## Application for a non-material amendment following a grant of planning permission. Town and Country Planning Act 1990

TWO STOREY AND SINGLE STOREY EXTENSION TODLETH VIEW  
CHURCHSTOKE MONTGOMERY POWYS SY15 6DY.  
GRID REFERENCE : 328272/293646.

M2006 0994

PROPOSED REAR ELEVATION

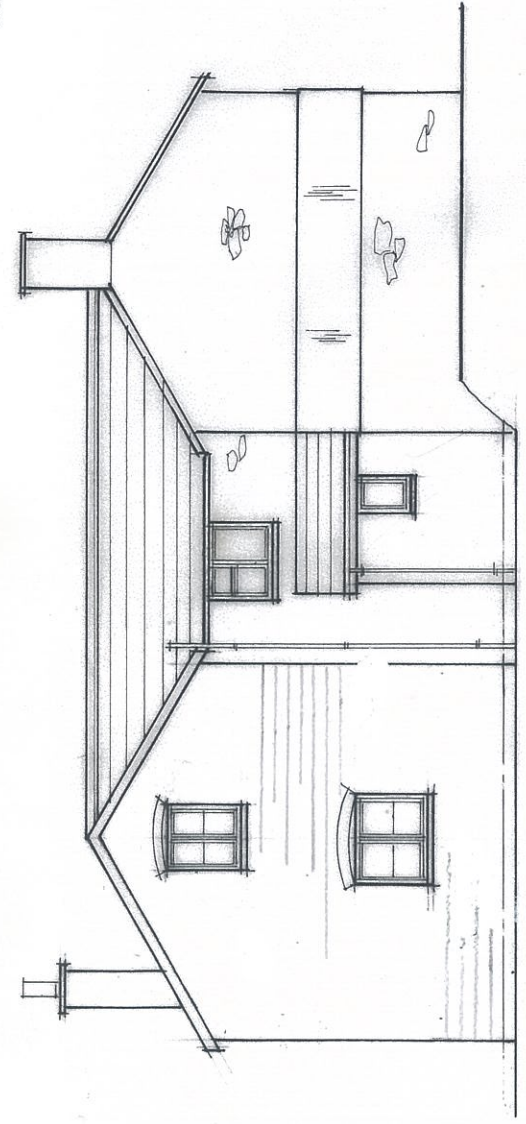
REPLACE EXTERIOR MATERIAL FOR END ELEVATION FROM NATURAL  
STONE TO TIMBER CLAD.  
REPLACE EXTERIOR MATERIAL FOR REAR ELEVATION FROM NATURAL  
STONE TO TIMBER CLAD.  
REPLACE LOWER SIDE ELEVATION PATIO DOORS TO WINDOW,  
RELOCATE AGA AND CHIMNEY PLACEMENT TO CENTRAL POSITION  
OF END ELEVATION.  
RELOCATE BOTH GROUND FLOOR AND FIRST FLOOR END ELEVATION  
WINDOWS FORWARD TO ALLOW FOR AGA AND CHIMNEY RELOCATION.
